CITY OF ALBUQUERQUE

Re: Horizon Blvd NE
8830 Horizon Blvd NE
30-Day Temporary Certificate of Occupancy
Transportation Development Final Inspection
Engineer's/Architect's Stamp dated 7-26-19 (C17D127)
Certification dated 3-23-20

Traffic Circulation Layout  
TCL001

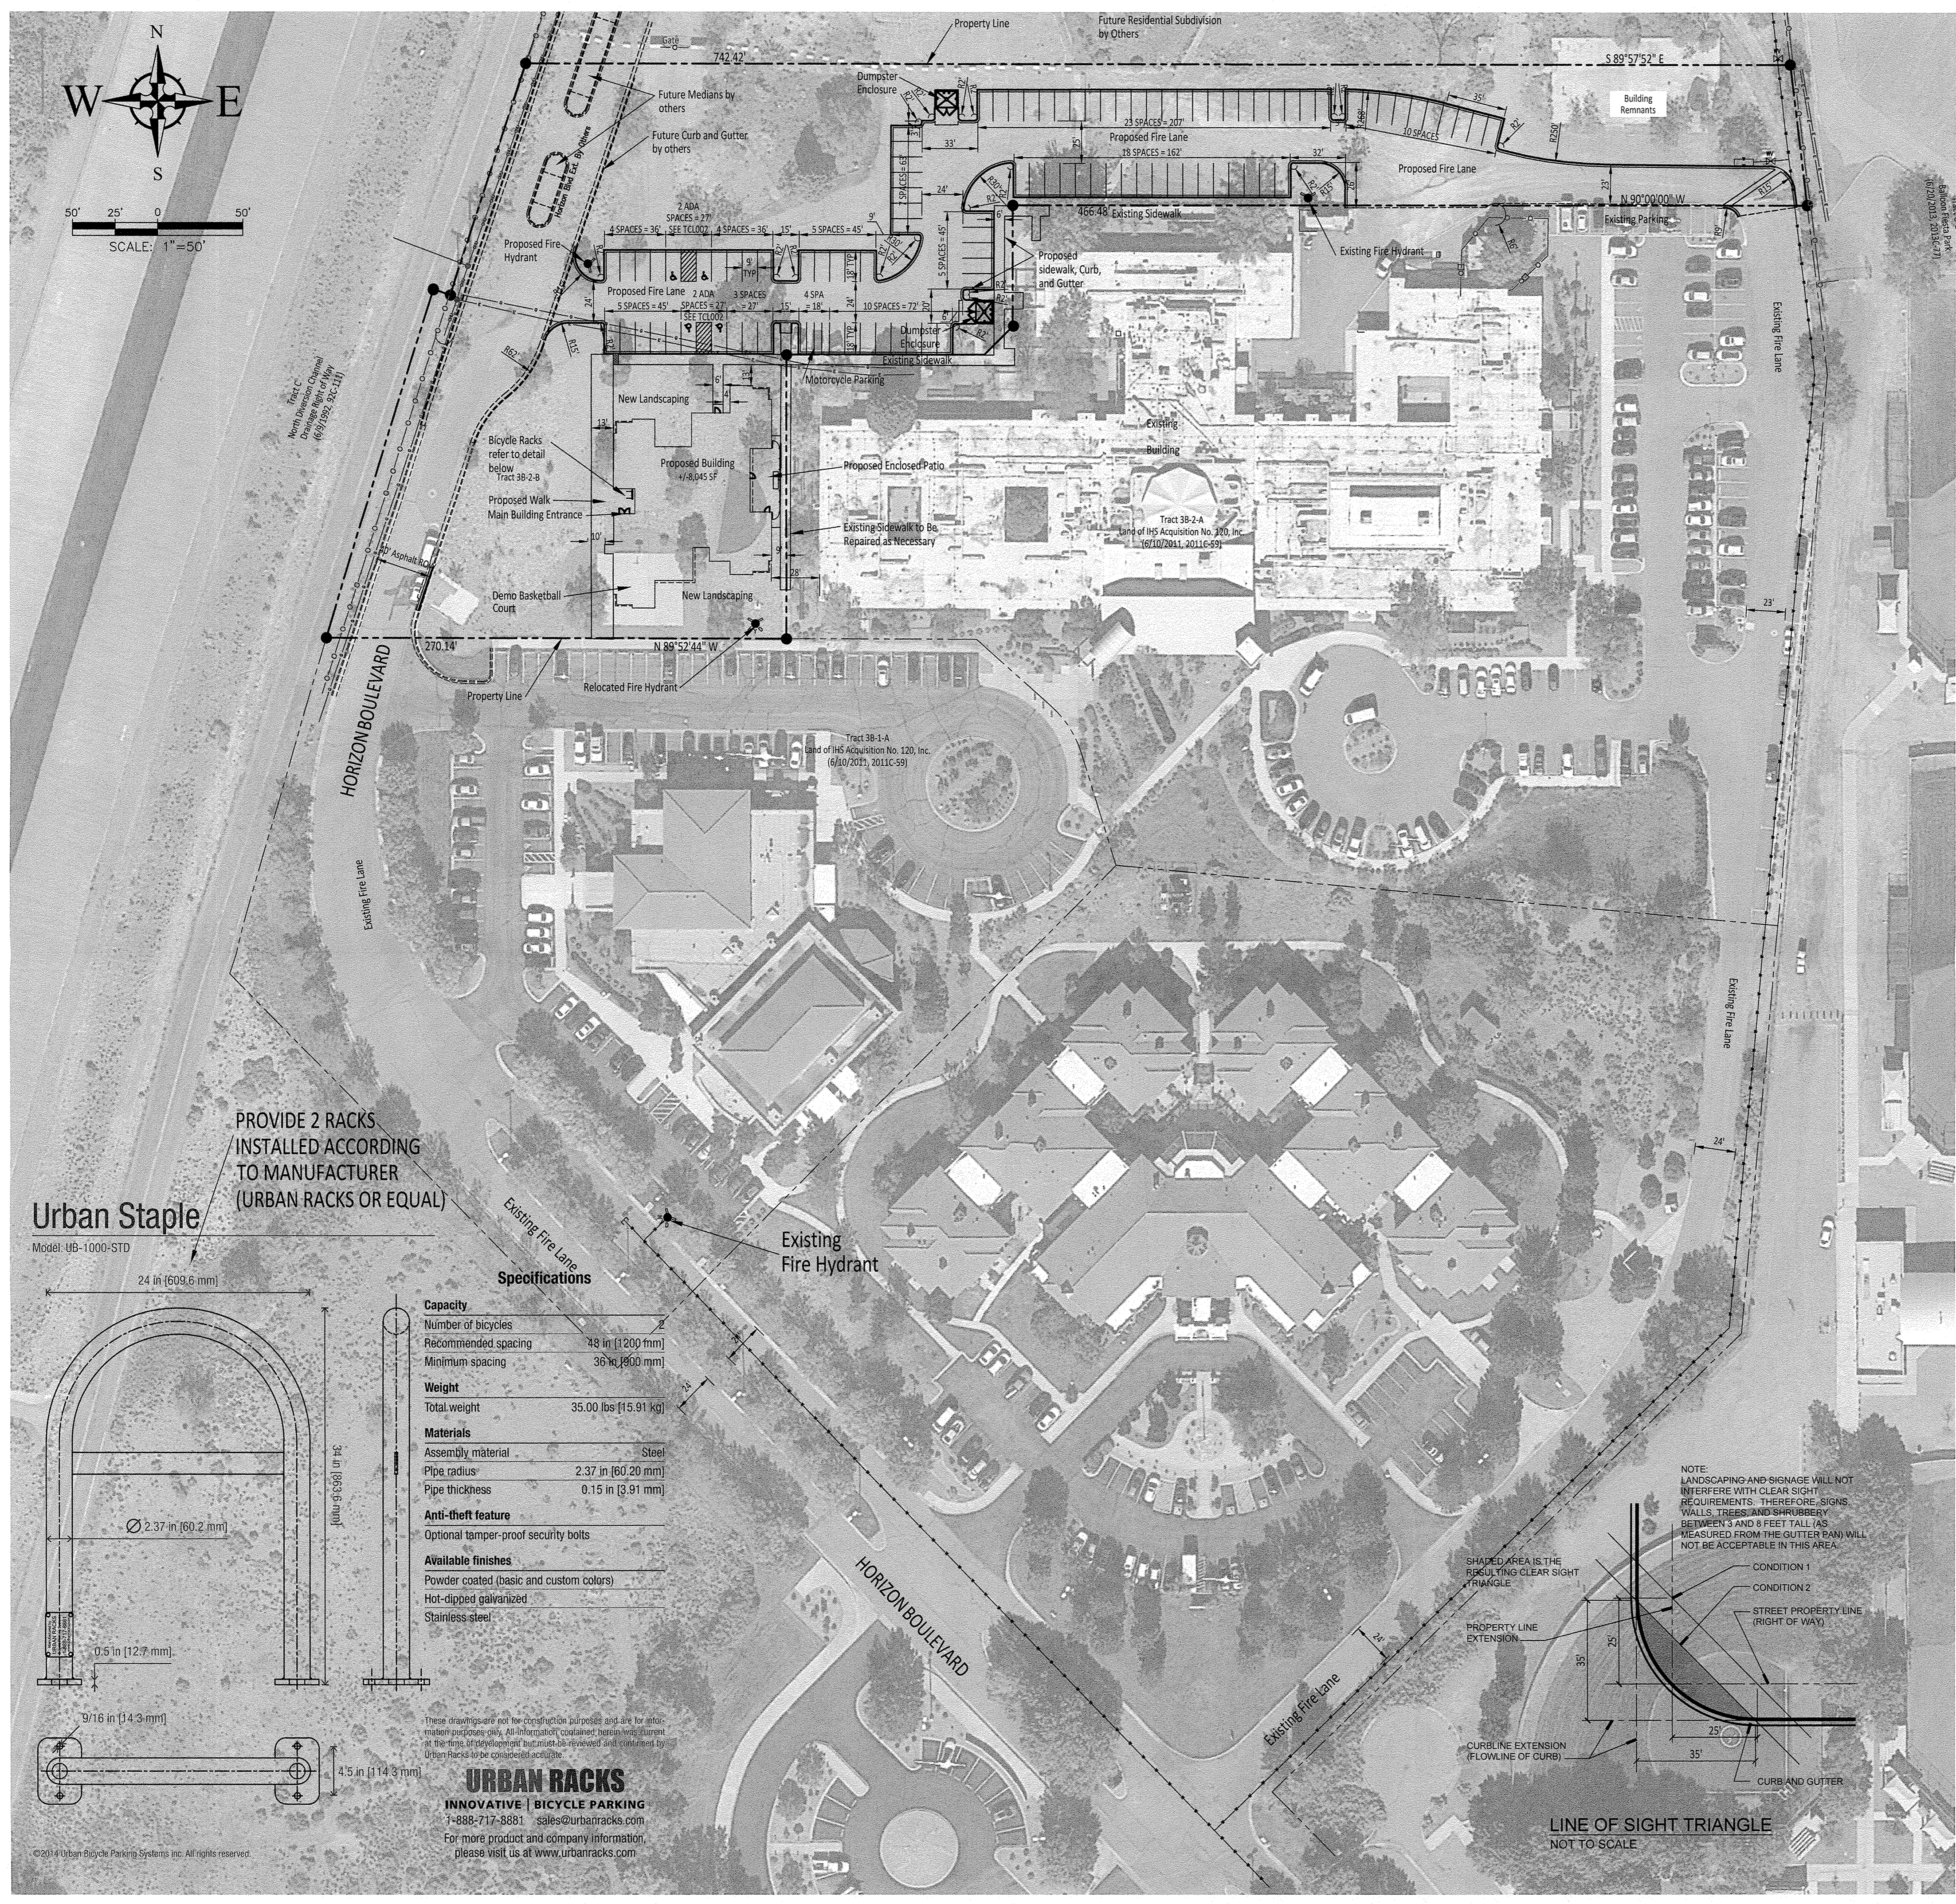
- Please complete asphalt paving on Horizon.
